13-15 Oxford Street, 17 Oxford Street and 2 Verona  
Street, Paddington  
Mixed-use Development

## OPERATIONAL WASTE MANAGEMENT PLAN

14/04/2026  
Report No. 707927  
Revision H

Drawing Title
BASEMENT 1 PLAN

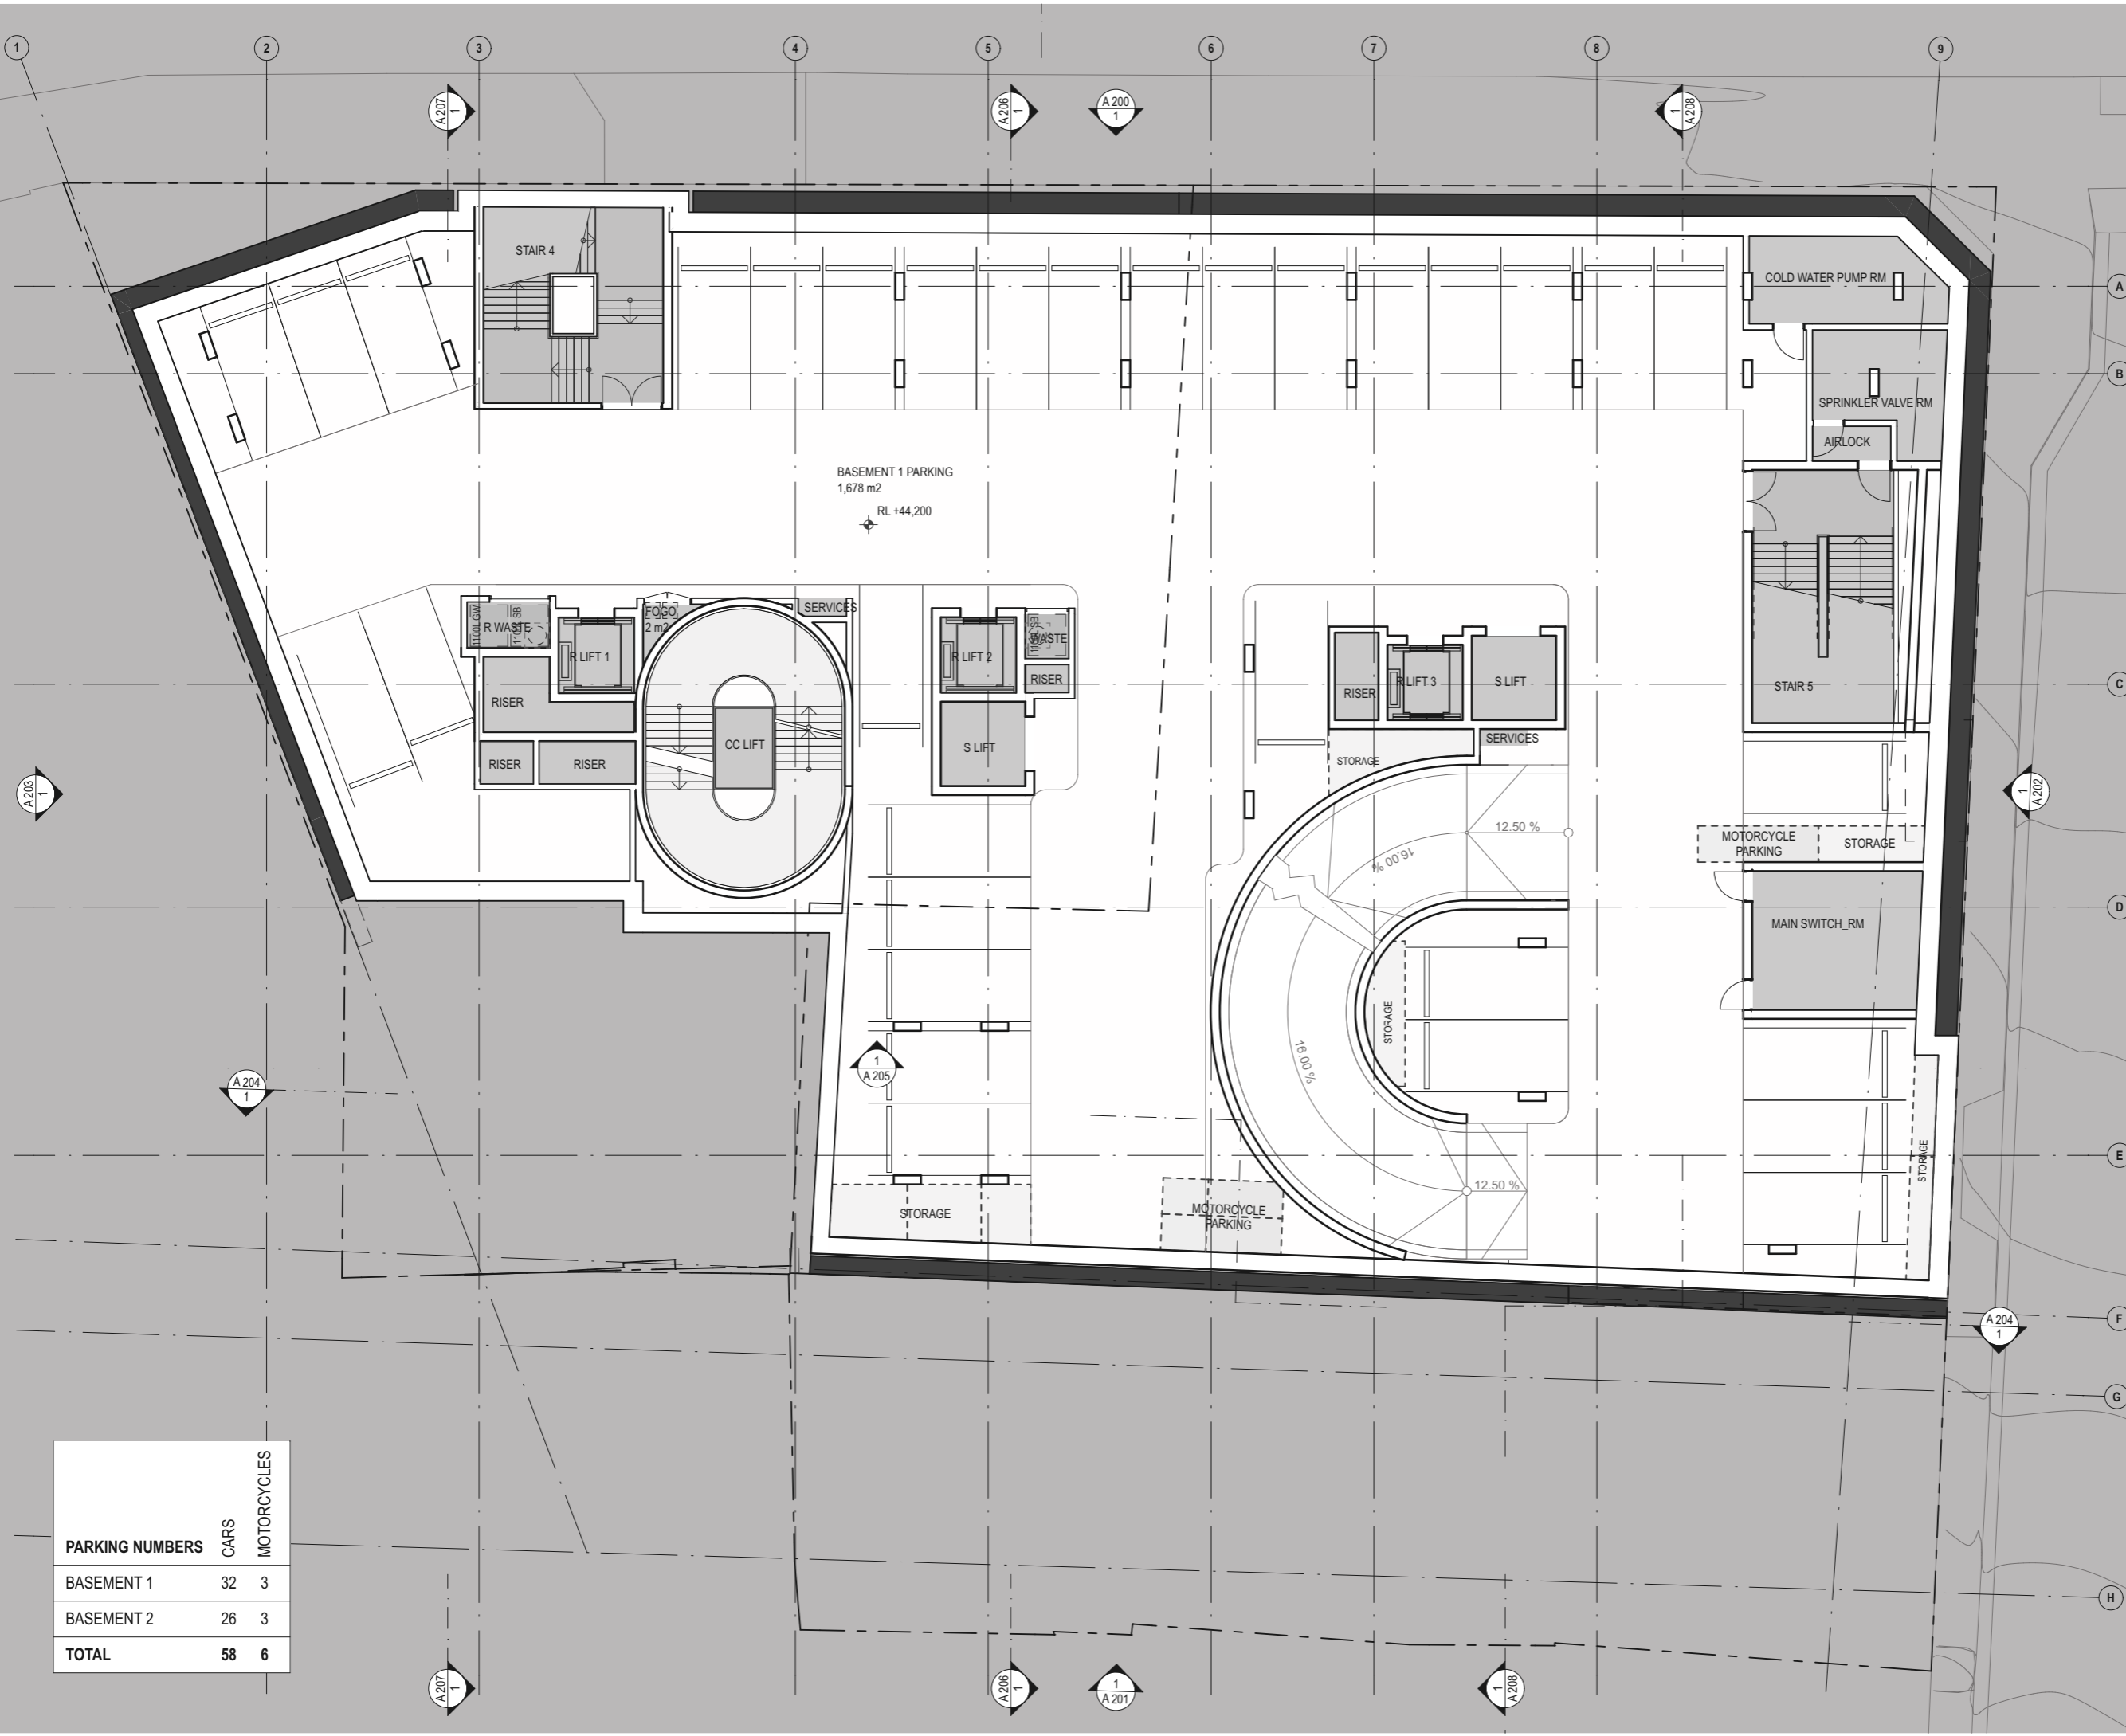
| <b>RFI Comments</b><br>Comments received from the City of Sydney Council<br>RFI reference #13.2 – Waste Collection                                                                                                                                                                                                                                | <b>RFI Responses</b>                                                                                                                                                                                                                                                                                                                                                                                                                                                                                                                                                                                           |
|---------------------------------------------------------------------------------------------------------------------------------------------------------------------------------------------------------------------------------------------------------------------------------------------------------------------------------------------------|----------------------------------------------------------------------------------------------------------------------------------------------------------------------------------------------------------------------------------------------------------------------------------------------------------------------------------------------------------------------------------------------------------------------------------------------------------------------------------------------------------------------------------------------------------------------------------------------------------------|
| v. Chute discharge rooms are required to be shown on the ground floor/ basement. Adequate space is to be provided for bins, clearances and linear track system/s to automatically rotate the bins. Information on how the bins will be moved from the chute discharge room to the waste collection room is required.                              | <p>All chute discharge rooms are shown on the architectural plans and accommodate the 1100L bins beneath the chute. This is reflected in Appendix A.1 and A.3.</p> <p>Based on the City of Sydney waste generation rates, residents should not be producing more than 120 L of general waste per week. Storing bins within a 2-bin 1100 L linear track system would equate to more than six days of waste accumulation, increasing the risk of odour issues, fire hazards, and operational challenges - particularly given the spatial constraints that limit the feasibility of installing such a system.</p> |
